Final Tree Officer Comments

Planning Application Ref: **AW/279/18/RES**

Location: **261 Aldwick Road, Aldwick, PO21 3QU**

Description of works: **Application for approval of reserved matters following outline approval AW/43/18/OUT for the demolition of existing dwelling & erection of two pairs of semi-detached houses & associated works**

Tree Retention and Protection Plan

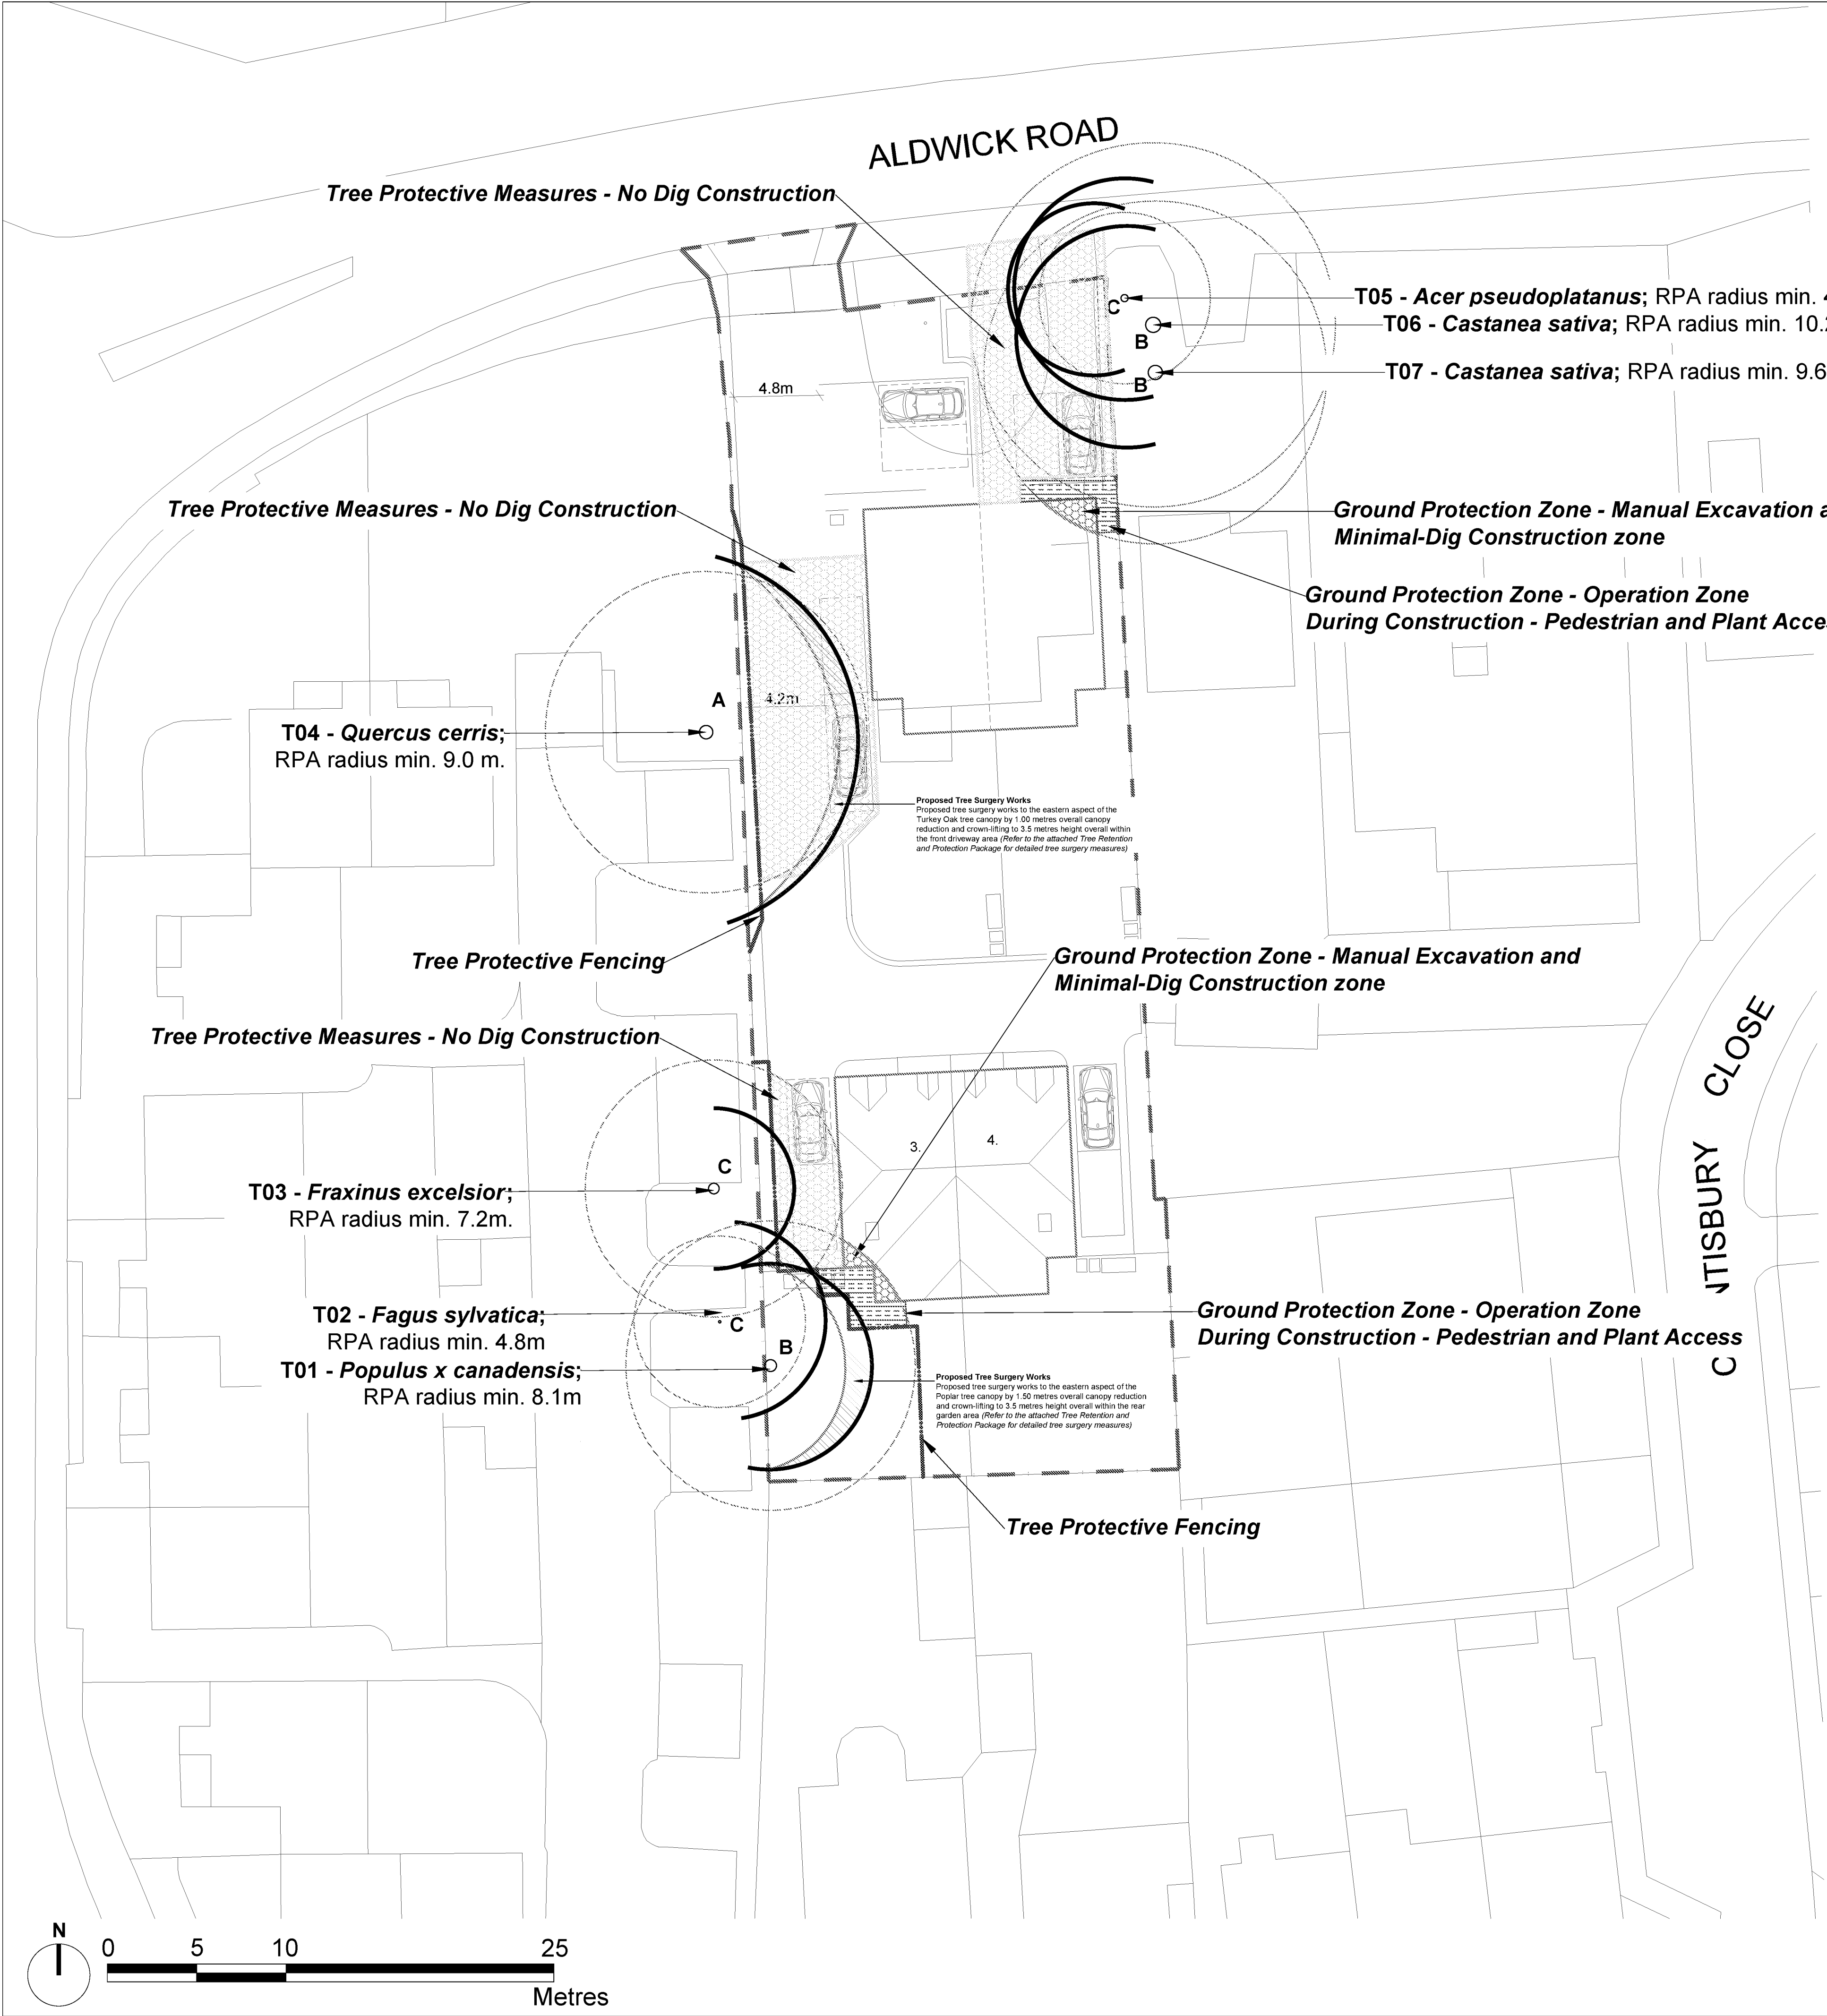
- It is disappointing that despite the earlier helpful refinements to the original documents/plans submitted with the outline application there remains for me an outstanding issue with the proposed 'Minimal-dig' solution for the main vehicle access route into the site. Progress has been made with making refinements to the AIA/AMS and TPP although still not enough detail to provide confidence those important trees will be adequately protected.

- I remain concerned with the 'Minimal-dig' Construction methodology as described in the AIA/AMS, 21/June/18, Rev 01 (p13, para. 4.29) which states that existing soft ground layers within Root Protection Areas are to be removed so as to provide the necessary construction depth and to meet with existing hard surface levels. This is not a 'No-dig' Construction, which is the only methodology I could support alongside these valuable trees. The AIA/AMS and TPP have been revised, with satisfactory reference to and improved description of 'No-dig' solution/methodology.

- The extent and depth of proposed ground level alteration has not been provided in detail or shown on any cross-section drawing, so we cannot be sure these trees will not suffer significant damage. Is it not possible to 'build up' soil levels slightly to achieve an acceptable platform, that better respects the trees? This remains a significant and

- If they can resolve the above concern to my satisfaction, by way of demonstrating how a true 'No-dig' Construction can be achieved across the site at those three areas identified on their Tree Retention and Protection Plan, dwg.no.LLD1245-ARB-DWG-002, Rev02, 21.06.18 and clearly write this into their AIA/AMS and to correspond with the TPP; then I would be able to remove my objection and recommend APPROVAL subject to the following conditions being applied:

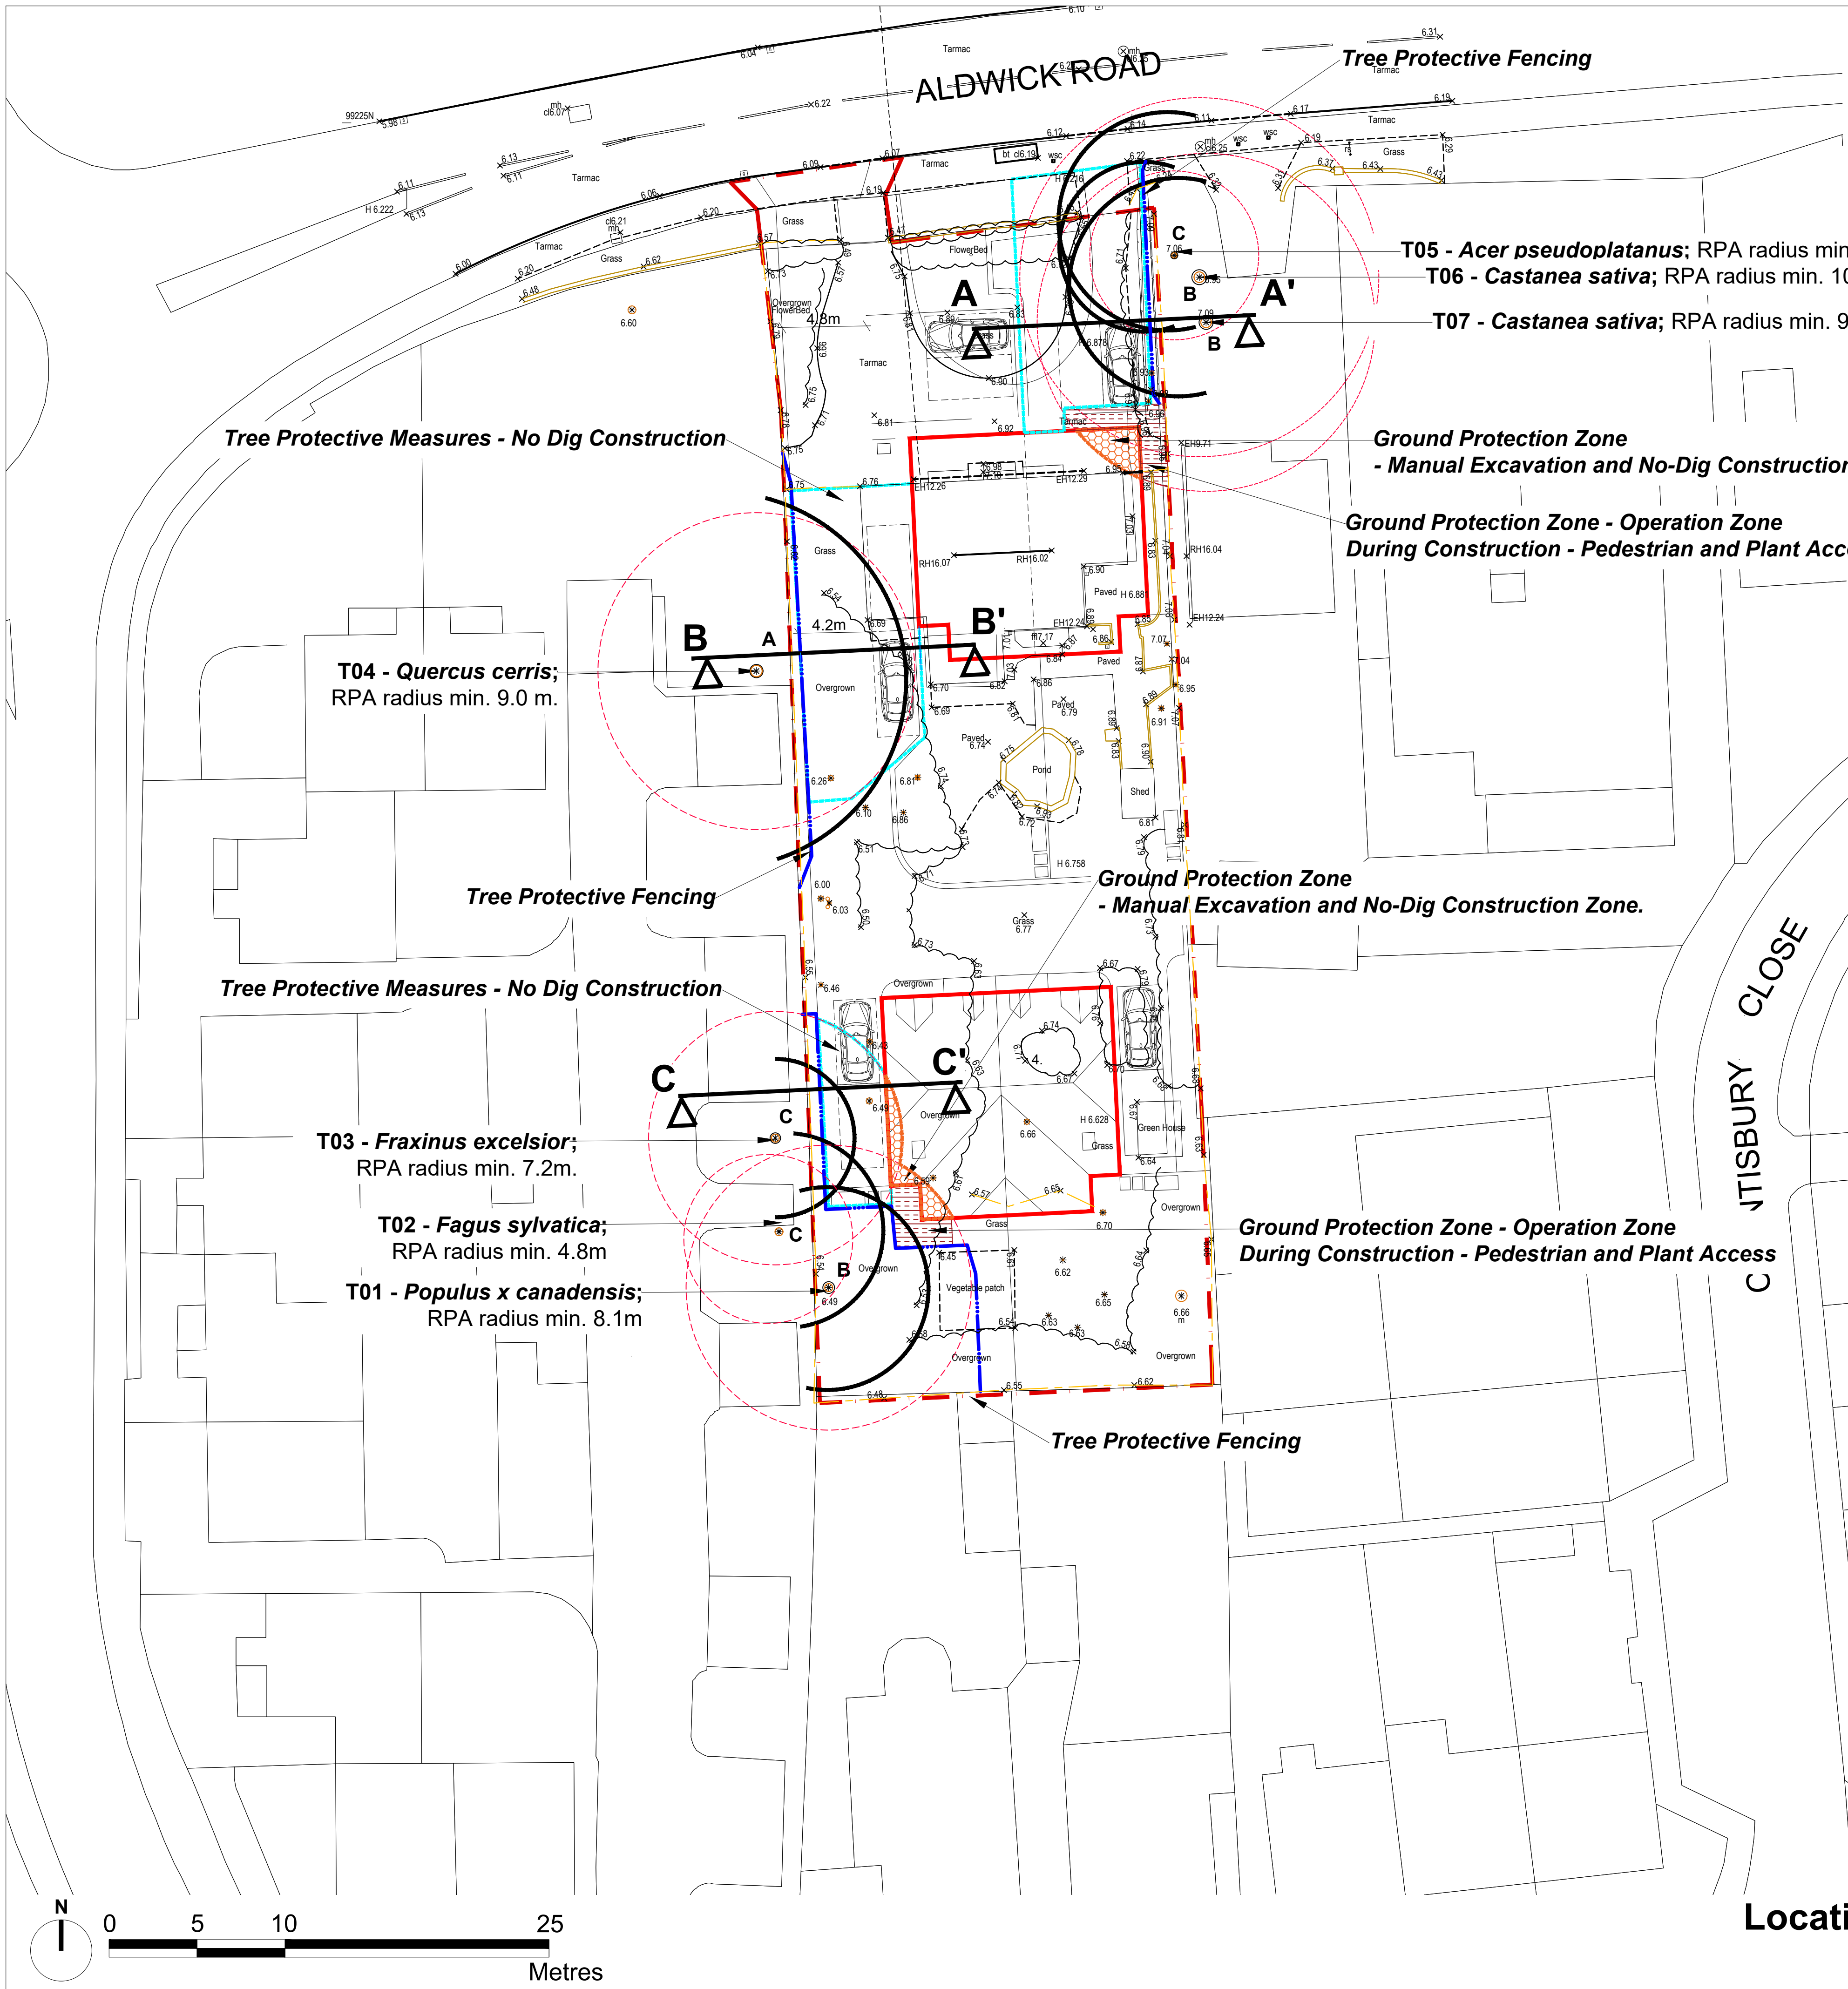
- I refer to my previous comments of 14th August 2018, in response to the aforementioned outline application.
- There is no additional information or revision of previous arboricultural submissions.
- Ensuring adequate protection for retained trees at this site is an ambitious undertaking and while achievable in theory, it presents a level of risk for tree damage that I am not entirely comfortable with. These are important trees locally and of high amenity value so should be afforded special consideration.
- The following plans dated 11th March 2019 have been submitted:
 - Section Lines / Existing Levels, dwg. no. LLD1425-ARB-DWG-003
 - Sections Through No-Dig Construction, dwg. no. LLD1425-ARB-DWG-004
 - No-Dig Construction Indicative Section / Detail, dwg. no. LLD1425-ARB-DWG-005

These demonstrate the feasibility of no-dig solutions at three separate locations across the site.
